28 May 2013

**Re: Exhibition of Mainfreight Dangerous Goods Storage Facility at 30 – 50
Yarrawa Street, Prestons**

Tanya O'Brien
Manager Strategic Planning

notes  
 This drawing is prepared for information purposes only. It is not to be used for construction.

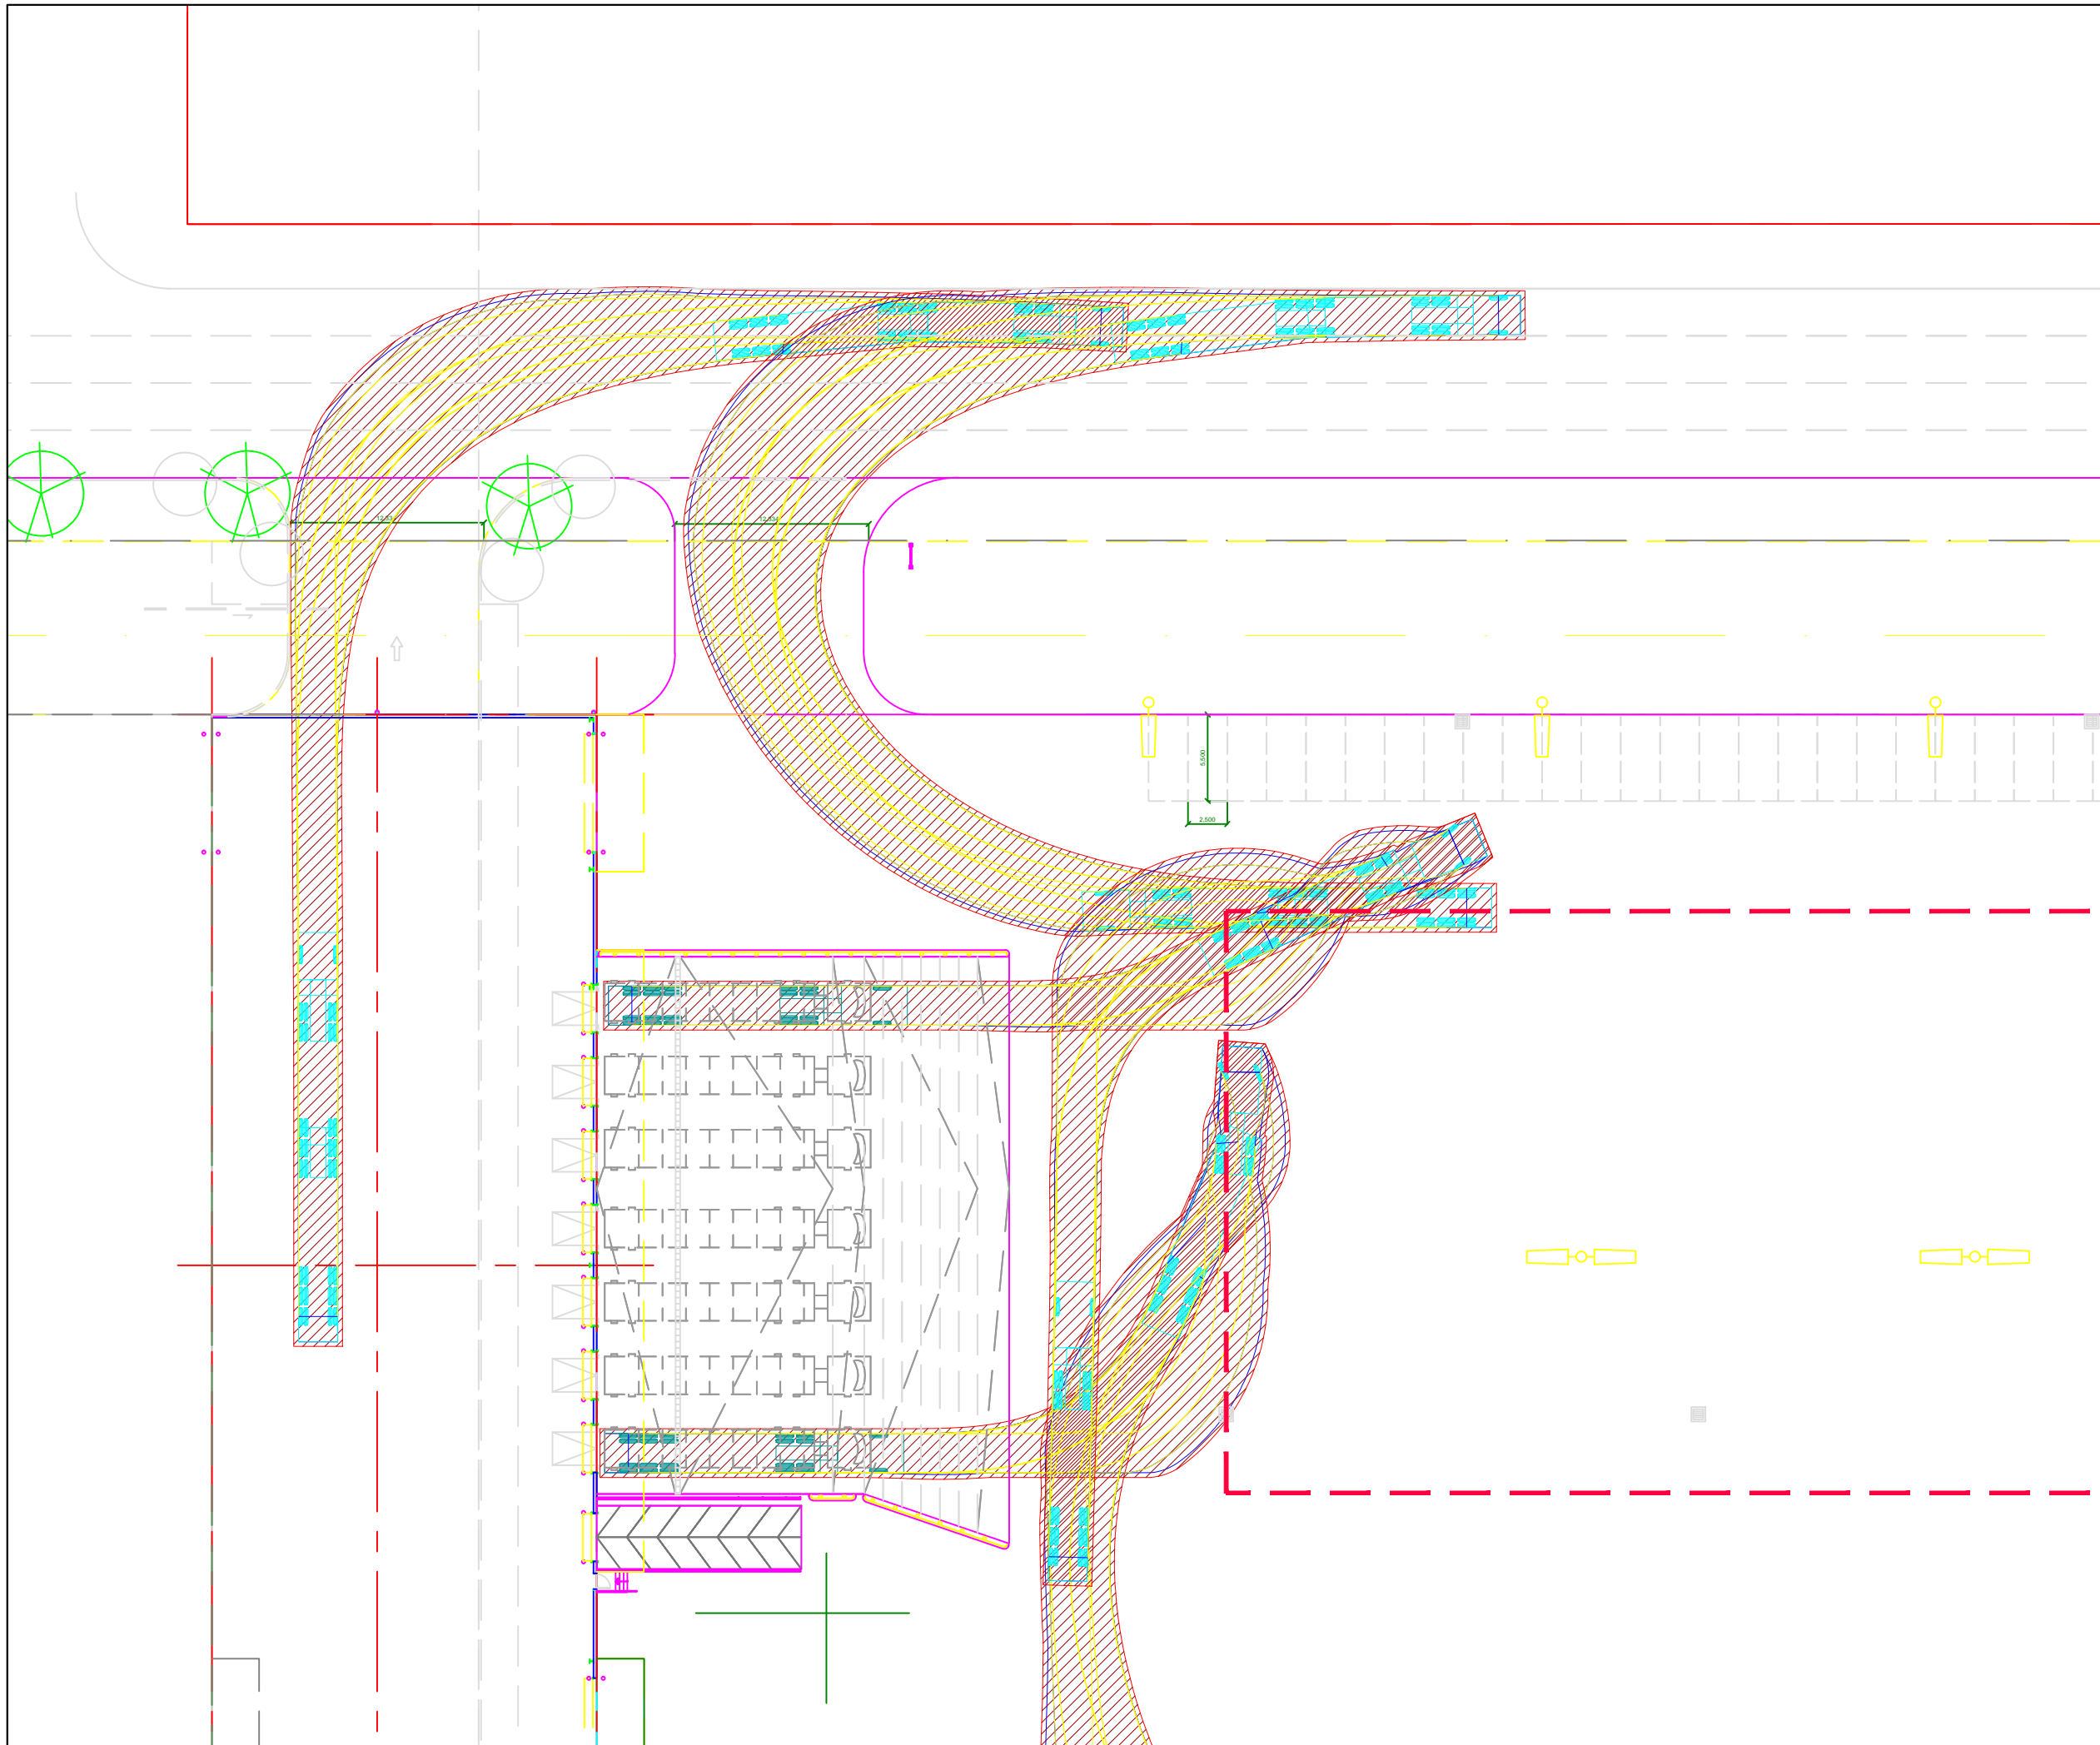
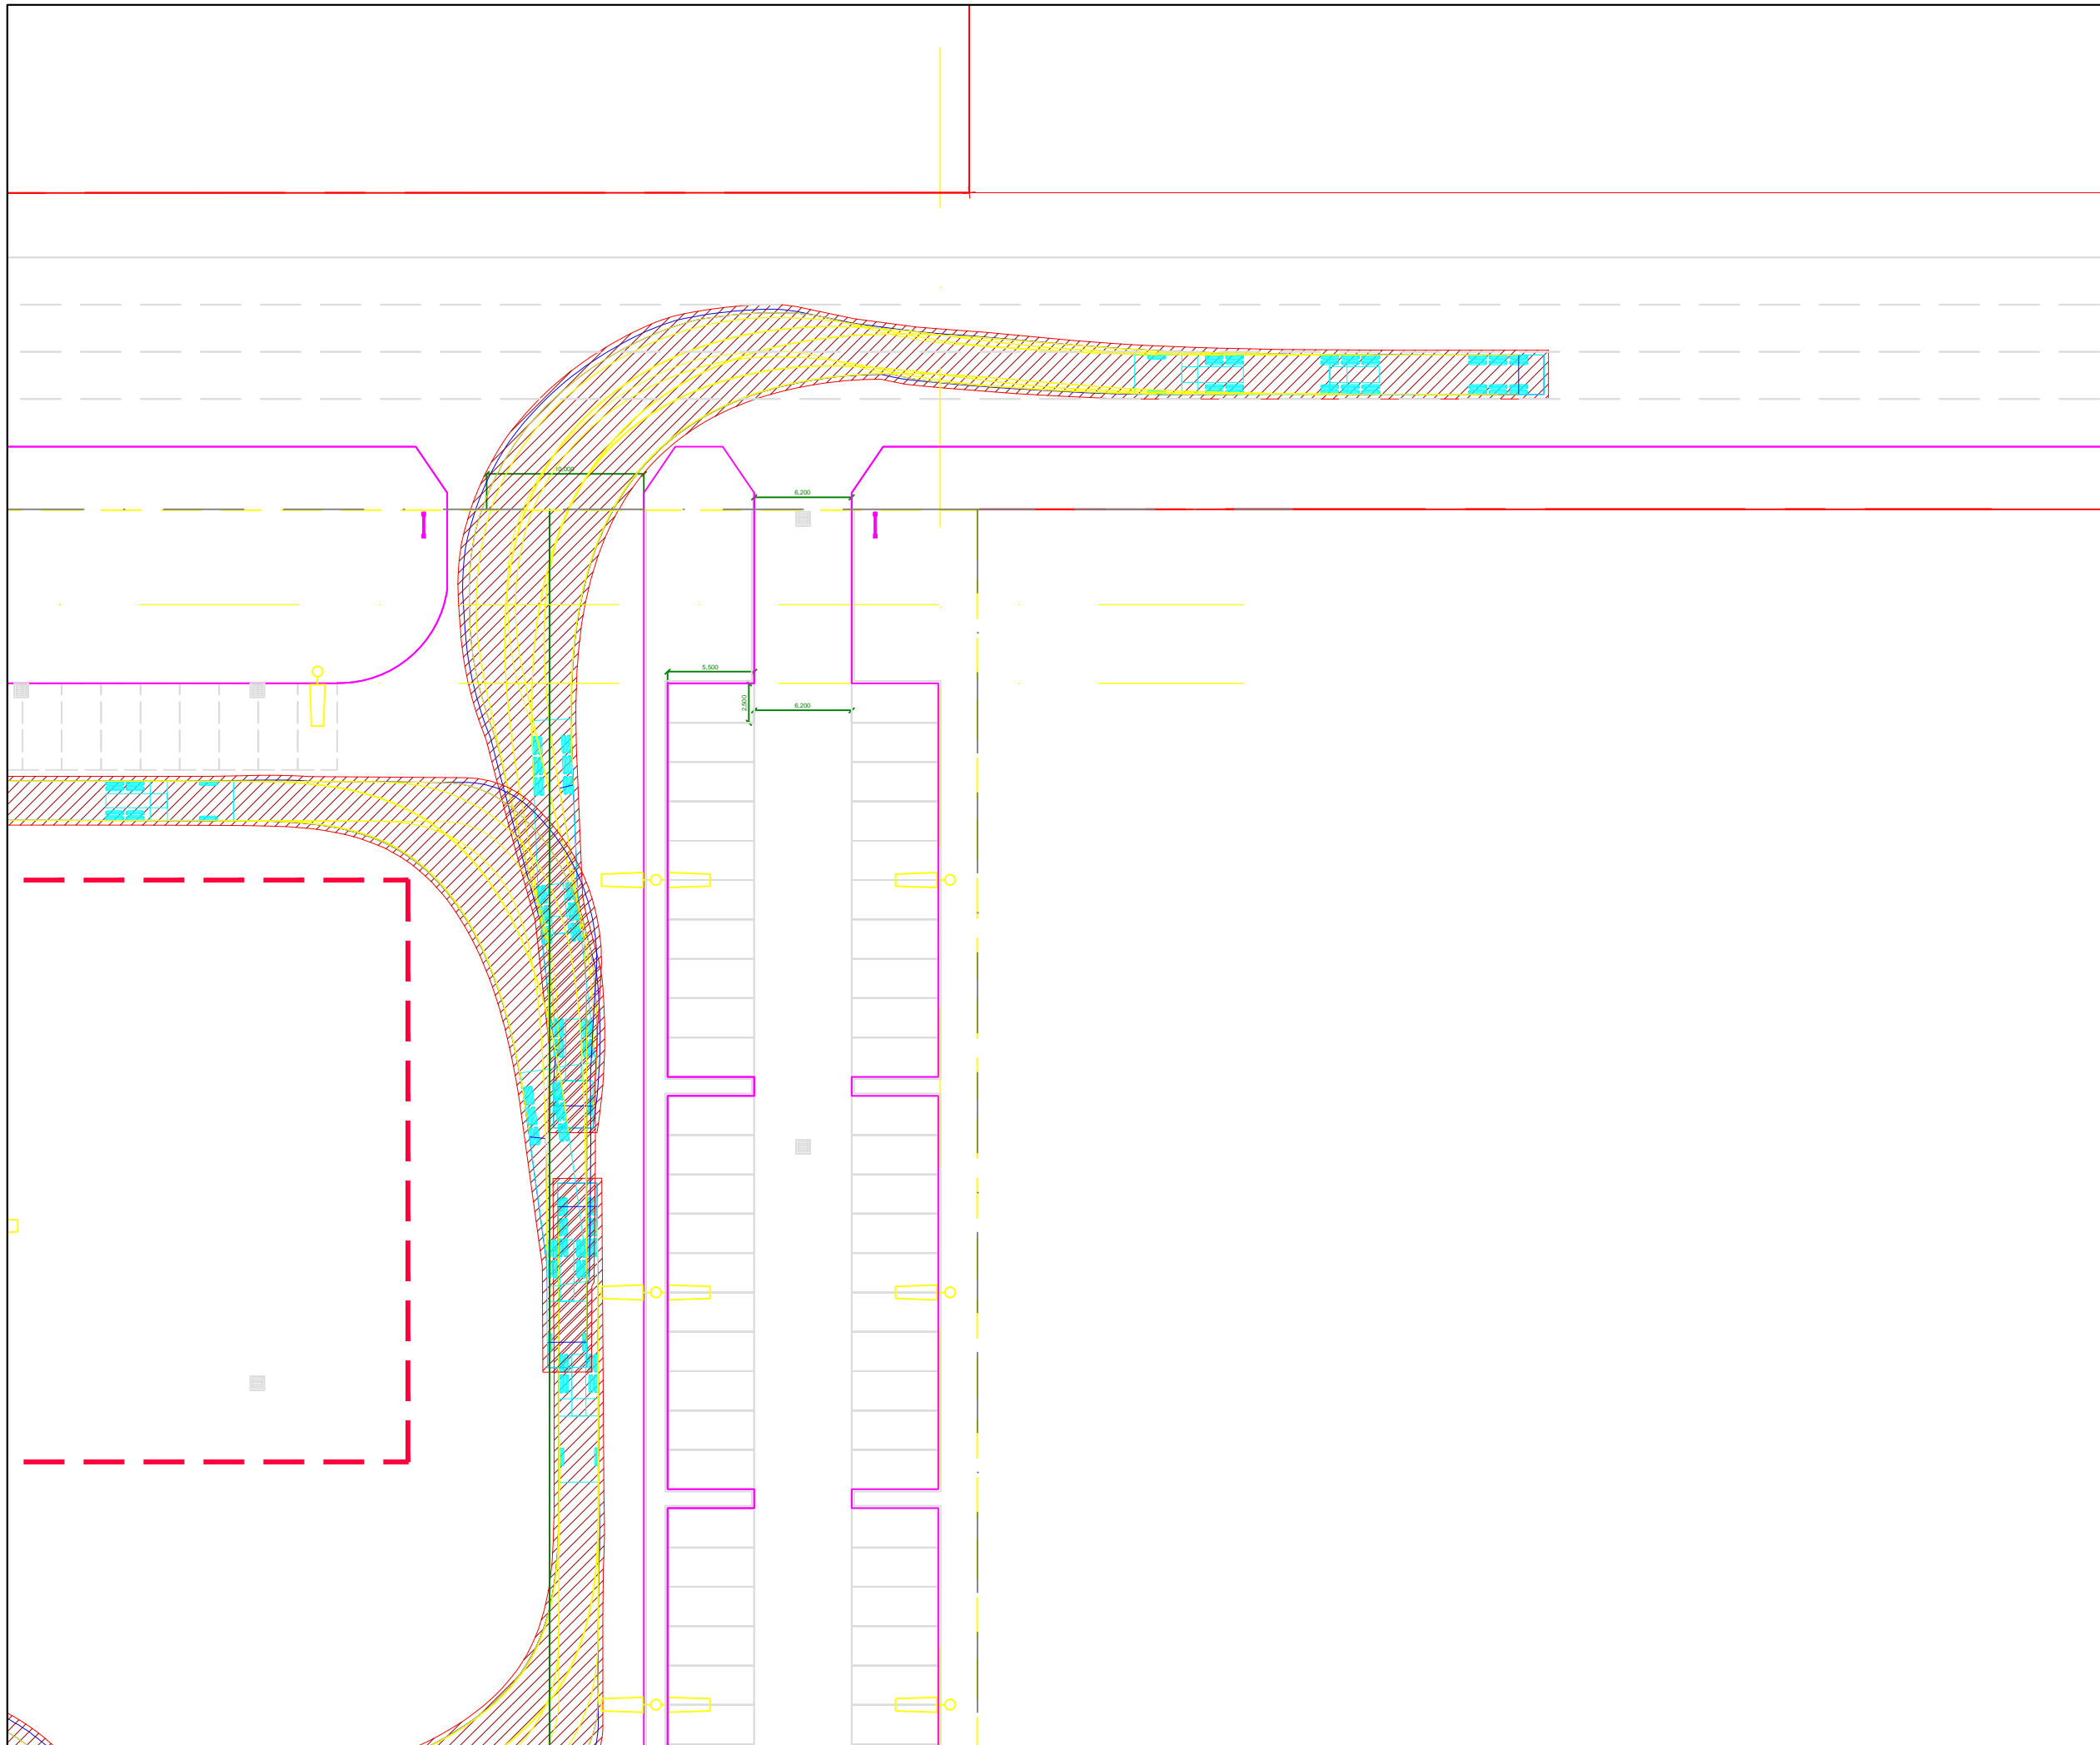
- The internal layout and proposed driveways for staff parking as well as the heavy vehicles are to be in accordance with Australian Standard AS2890. The driveways for the heavy vehicles for the B-double trucks are to ensure that they can accommodate the swept path of a 26m B-double.

3. Truck parking swept path. A layout demonstrating the truck storage can accommodate the swept path of a 26m B-double and also ensuring that such trucks can enter and leave in a forward direction.

DRAWING TITLE  
CONCEPT STORMWATER PLAN  
SHEET 1

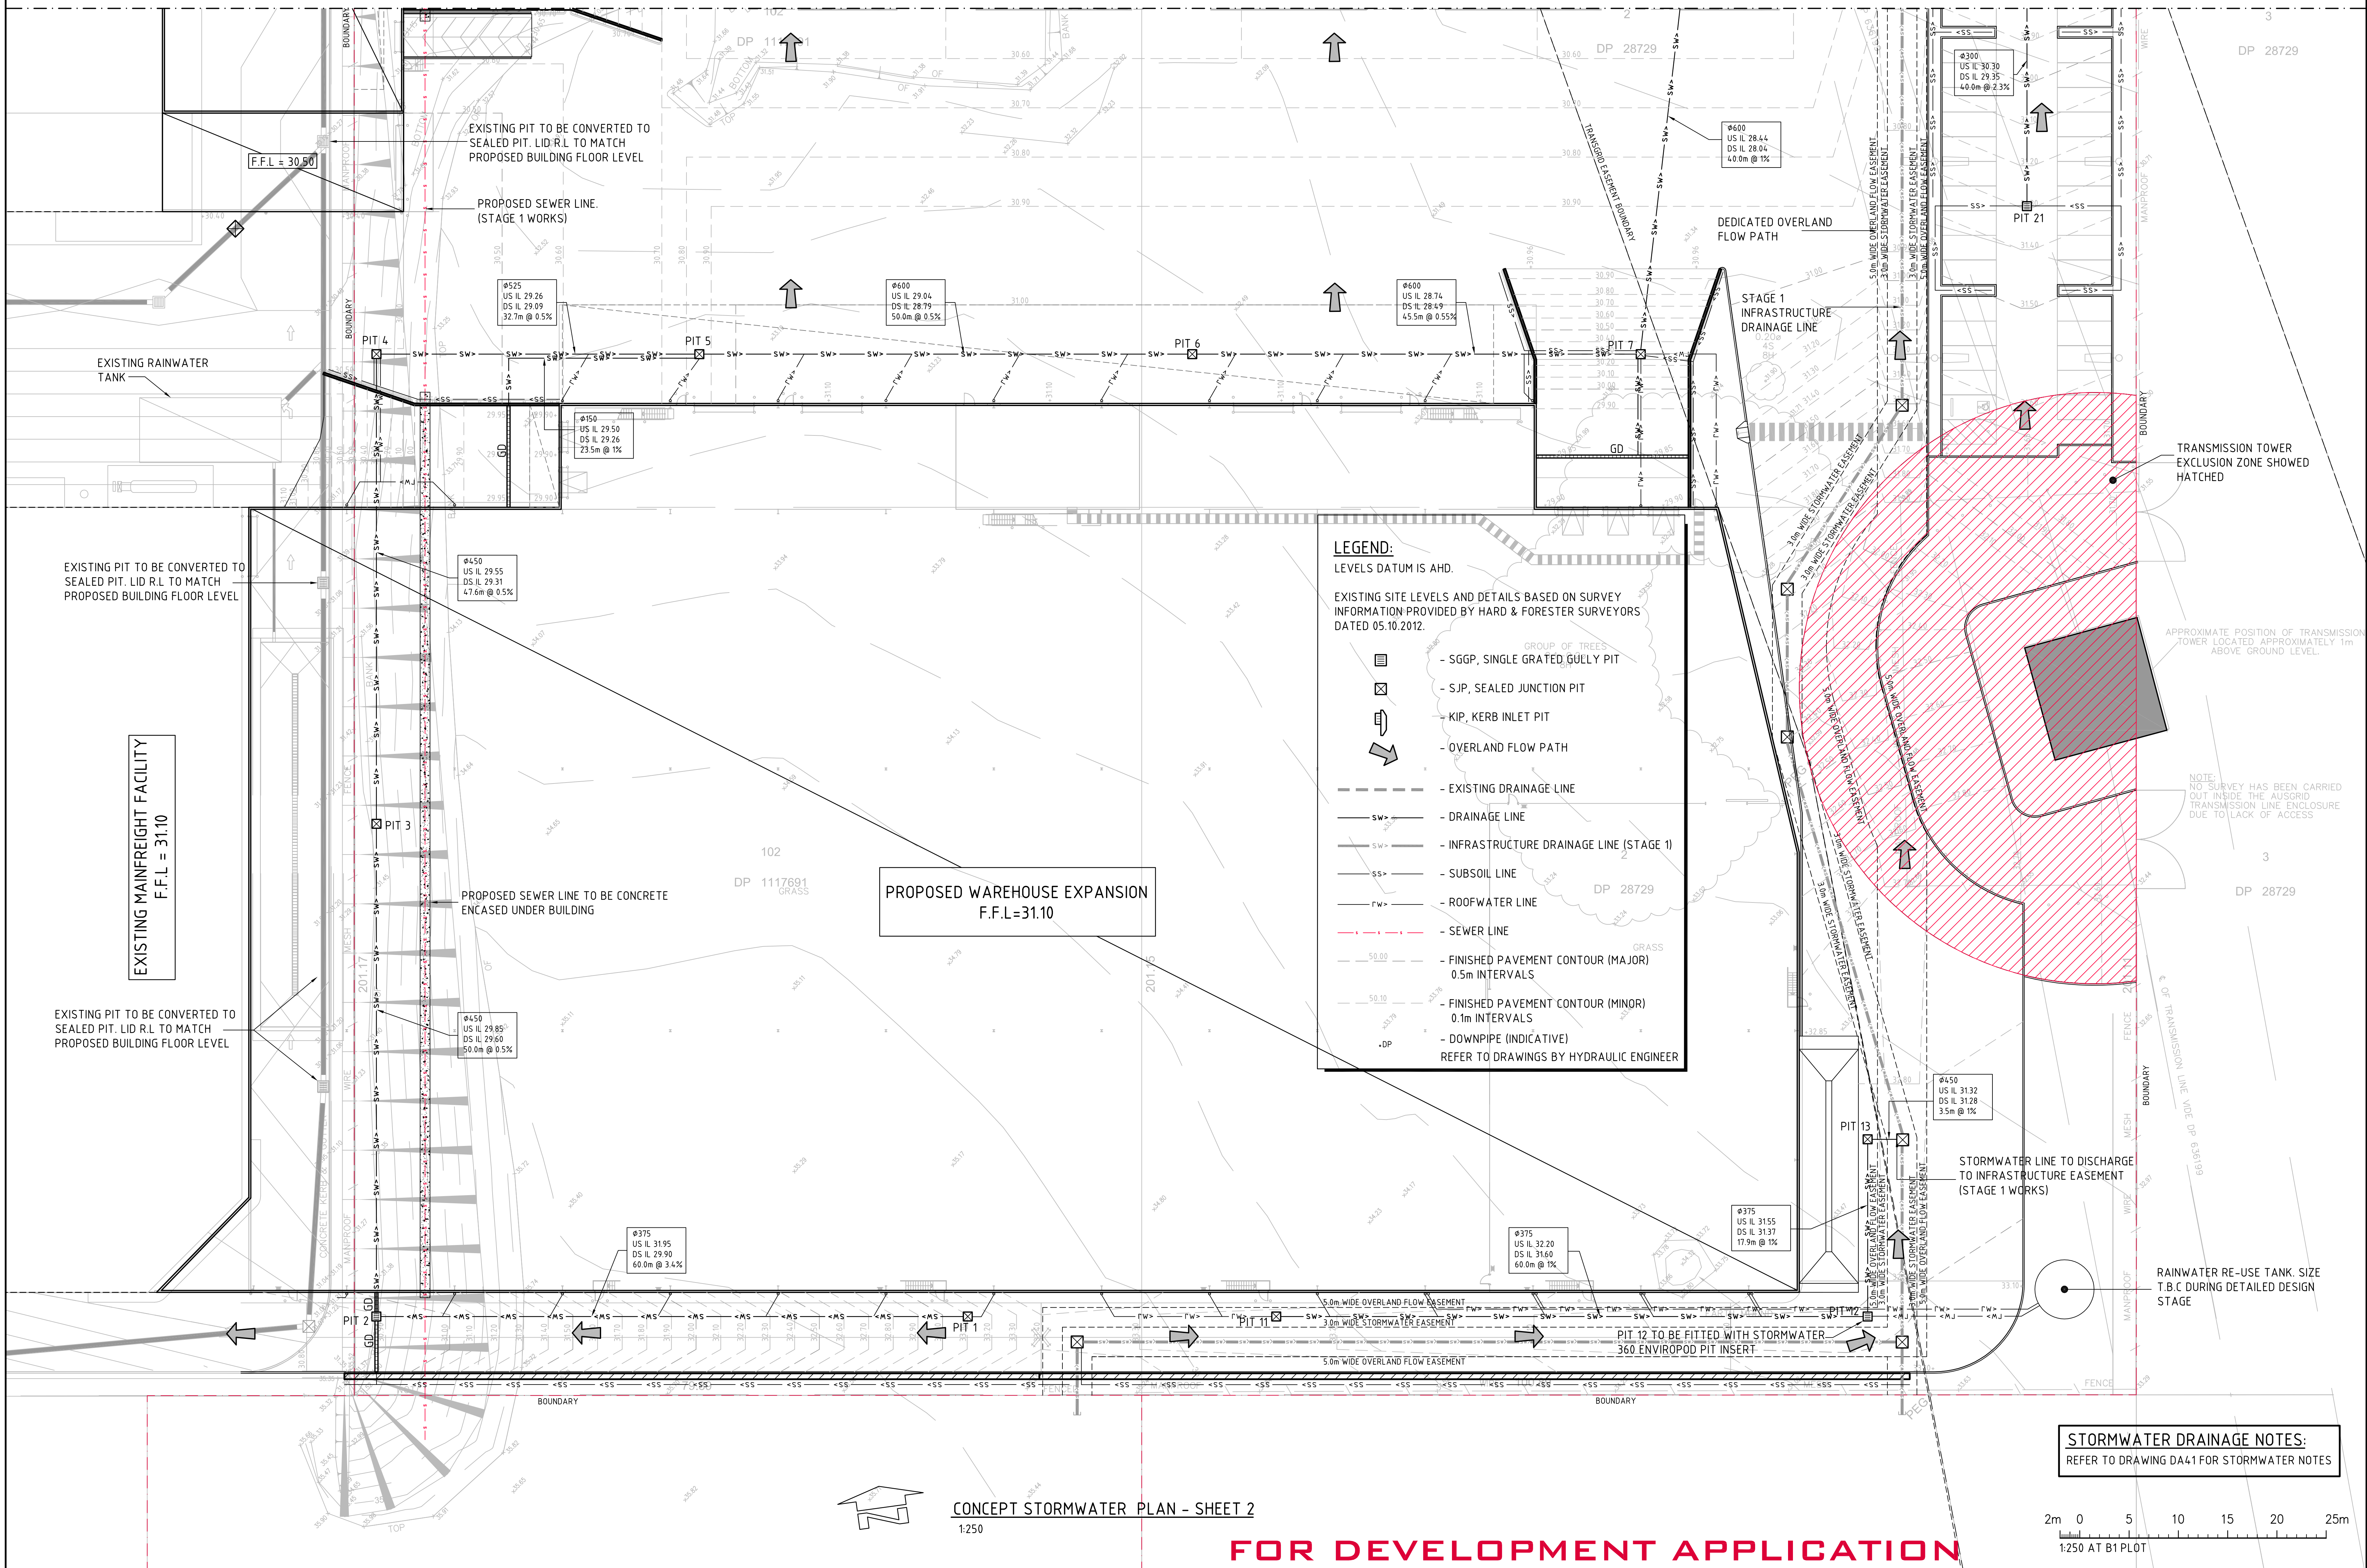
The information provided by DP&I on 20 May 2013, includes design details & hydraulic modelling of stormwater drainage system. However it does not include requested works as executed plans and CCTV survey of the existing drainage line at Yarrowa Street. In the absence of full information as requested, we are unable to undertake full assessment of the proposal with regard to stormwater drainage issues.

1. The proposed development will significantly increase peak stormwater discharge from the site. In order to mitigate adverse impact on existing drainage system Council requires that On-site Detention (OSD) be provided at the development site. The OSD shall be designed to restrict post-development flows leaving from the site no greater than pre-development up to and including the 100year ARI event (refer Council's OSD policy & technical specification).
